**RE: Residence Inn at Highlands
Grading & Drainage Plans
Engineer's Stamp Date: 10/22/2024
Hydrology File: K15D034D**

Based upon the information provided in your resubmittal received 10/22/2024, additional information and correction to the Grading Plan Sheet C100 – NOTE is required prior to issuance of Building Permit.

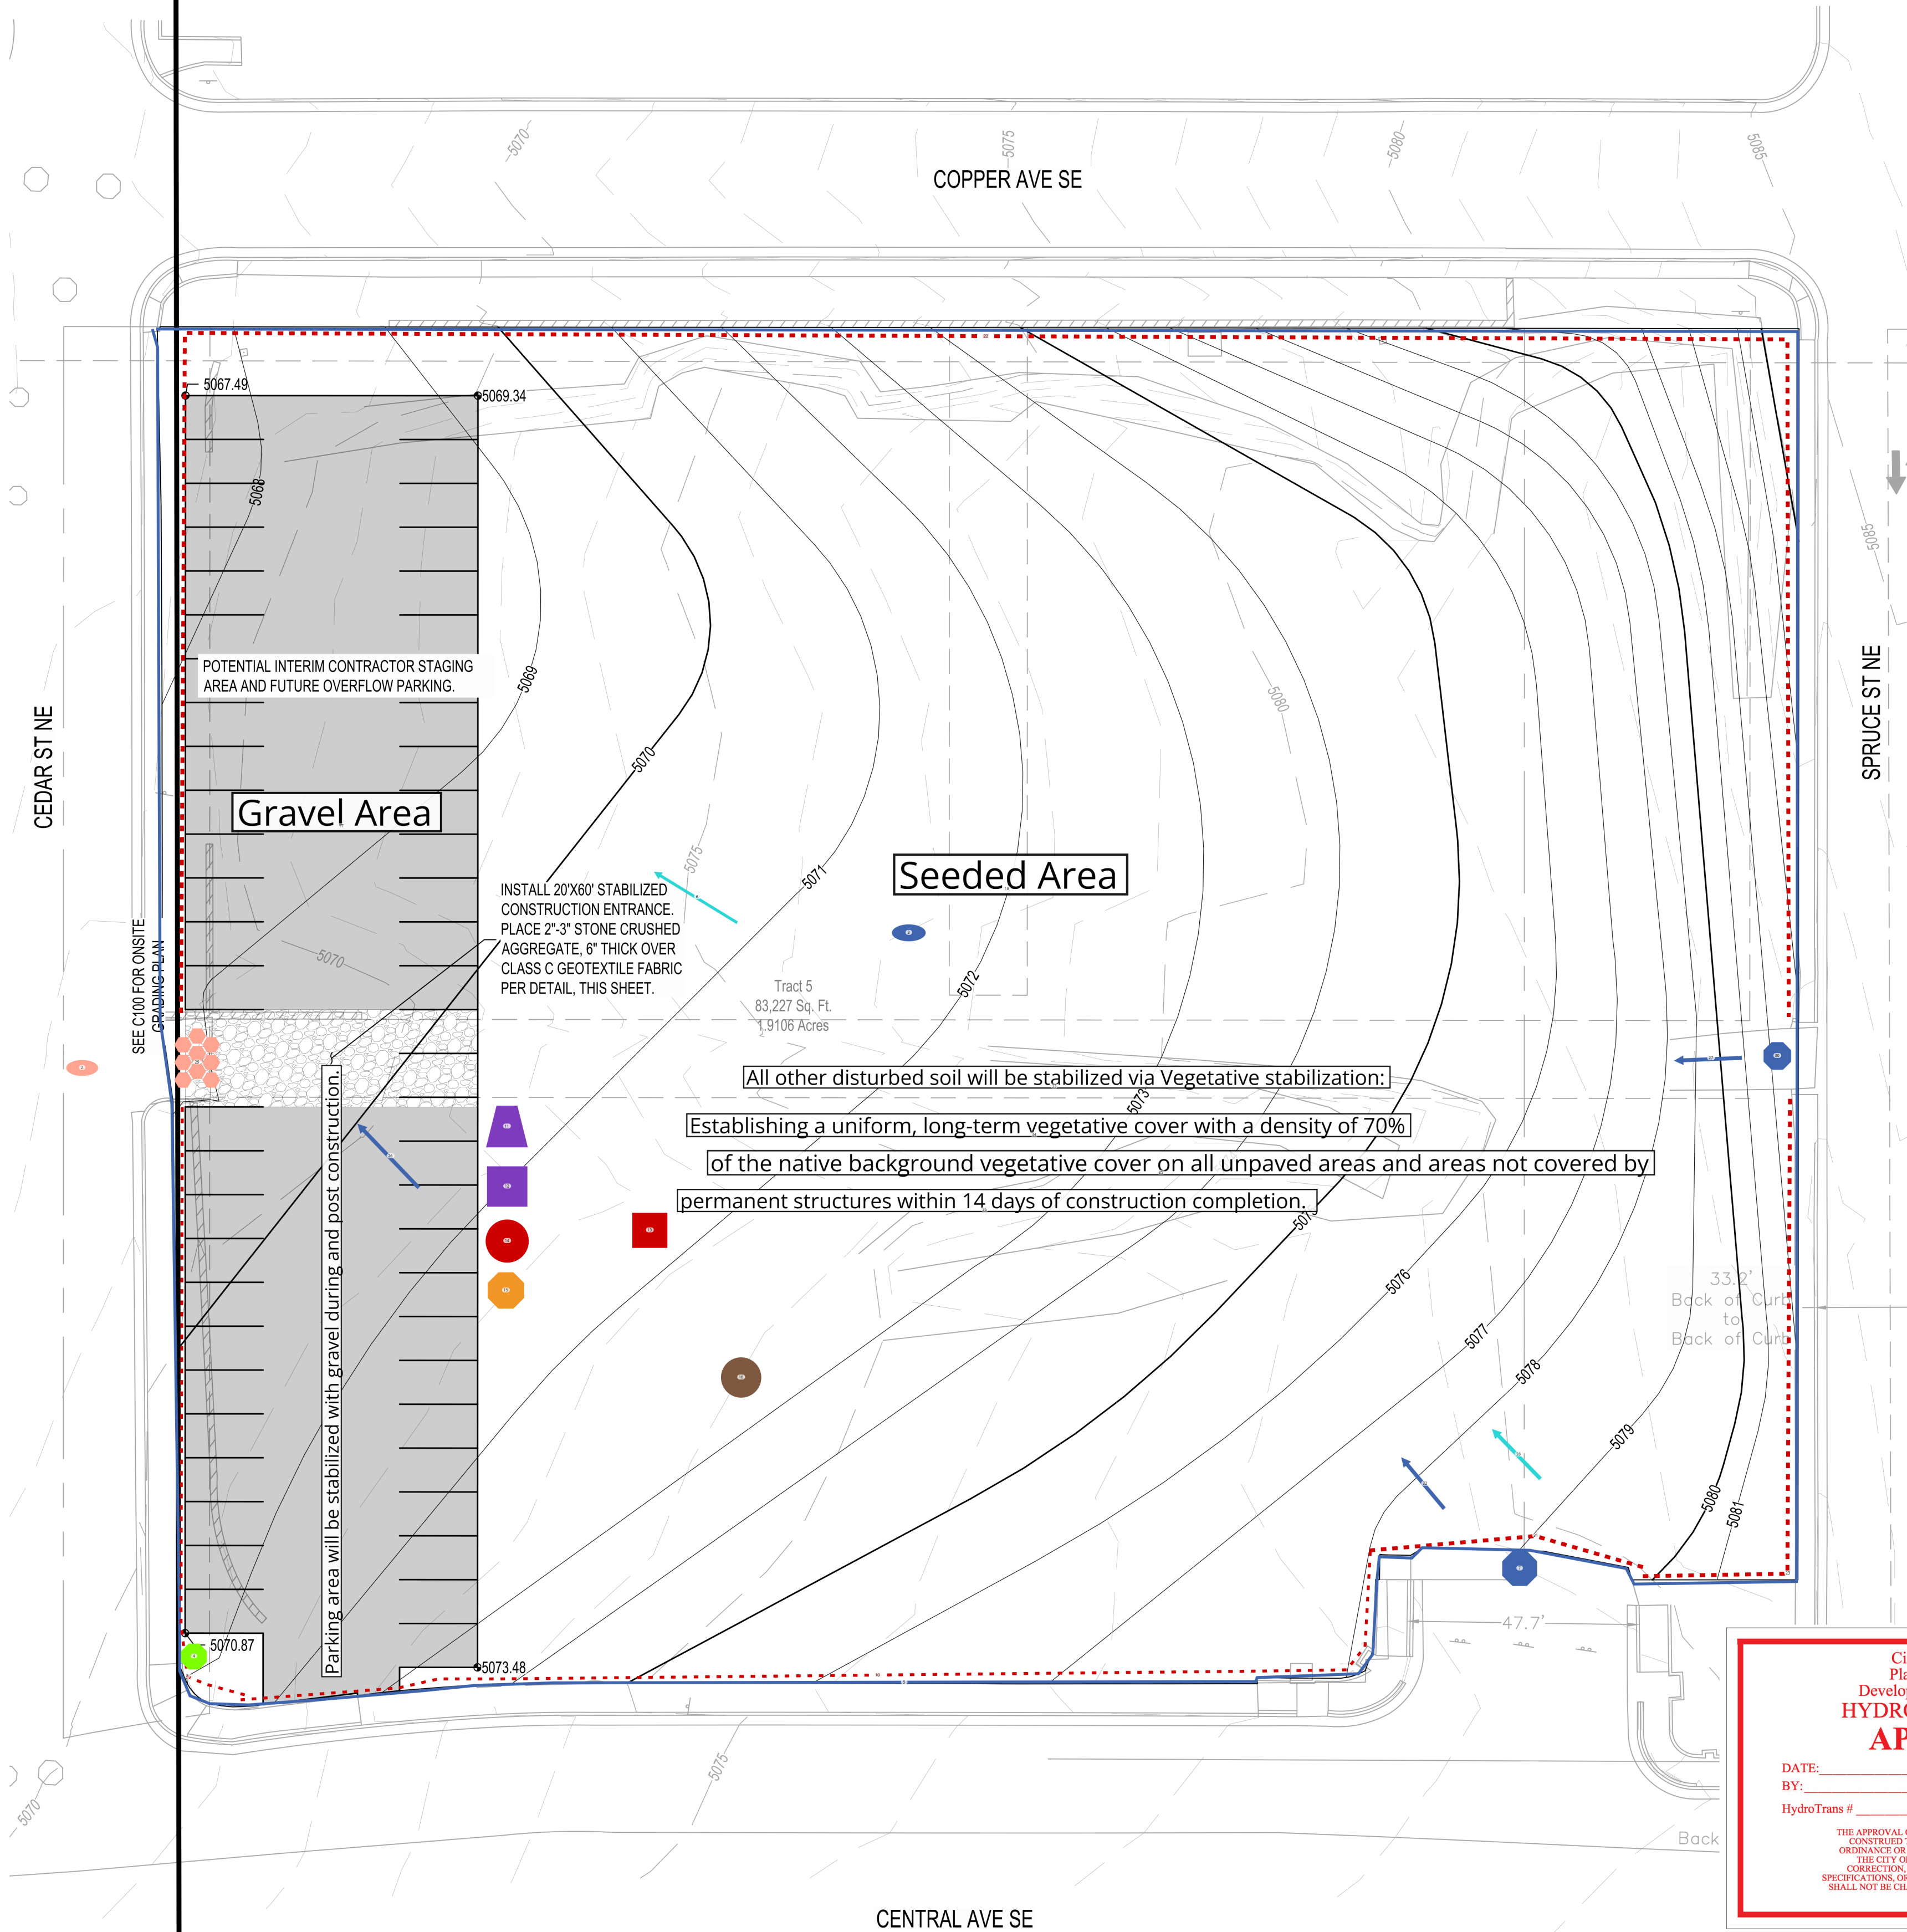
1. Payment in Lieu (Amount = $2985\text{CF} \times \$8/\text{CF} = \$23,880$, per Approved amounts below, and a note to be included on said Sheet C100) of onsite management of the SWQV must be made. Take three copies of the Treasury deposit slip to the Treasury and then include one copy of the paid deposit slip when resubmitting.
2. Please add a note which states, "The Owner has elected to pay the Payment in Lieu of the required Stormwater Quality Volume," together with the amounts mentioned above.
